RE: New Maitland Hospital – Stage 2 (SSI-9775), Request for Additional Information

We refer to your Request for Additional Information letter dated 30 October 2019 and the additional matters raised by Transport for NSW in relation to the bus bay layout. Please find our response below:

Landscape General Arrangement Plan
Quadrant A4

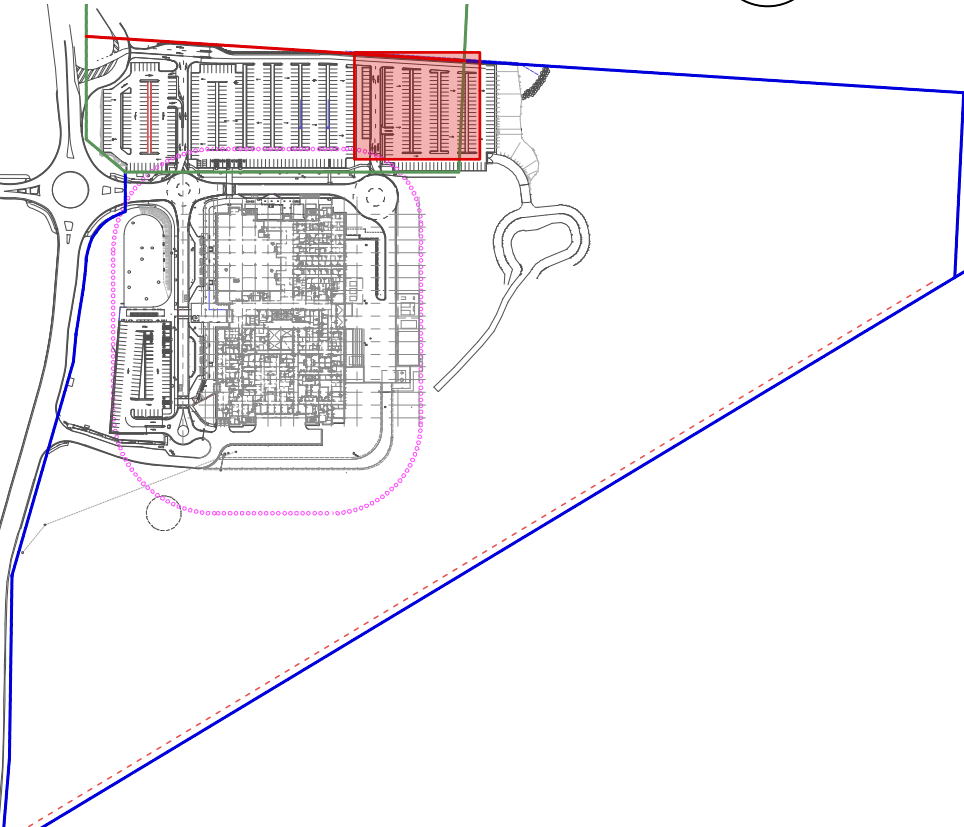
It is requested that a bus lay-by in addition to the bus bays in the amended plan (Site Plan, Drawing number 01A-AZ0-102) be provided on the opposite side of the internal road to future proof for potential growth of demand, as well as any future services which may commence terminate from the hospital.

As a preferred arrangement, it is recommended that taxi/pick up bays should not be provided in front of a bus stop bay.

It is requested that further consideration should be given to the placement of this pedestrian crossing from safety and bus operation perspective.

A bus layover for 2 x buses is added to the Northern side of the bus and taxi drop-off/ pick up area.

The drop off taxi / pickup is switched with the bus bay to align with the Guidelines for Public Transport Capable Infrastructure. This removes the requirement for a kerb extension (blister).

A second low profile pedestrian crossing has been added in the current pedestrian path location - we understand that the key concern was in regards to the safety of pedestrians utilising the pedestrian pathway to the east of the Northern entrance, given the interaction with the adjacent bus bays. This pathway was included in the design as it is a logical route for pedestrians accessing the Eastern half of the Northern car park, and it is therefore not recommended to be removed/relocated.
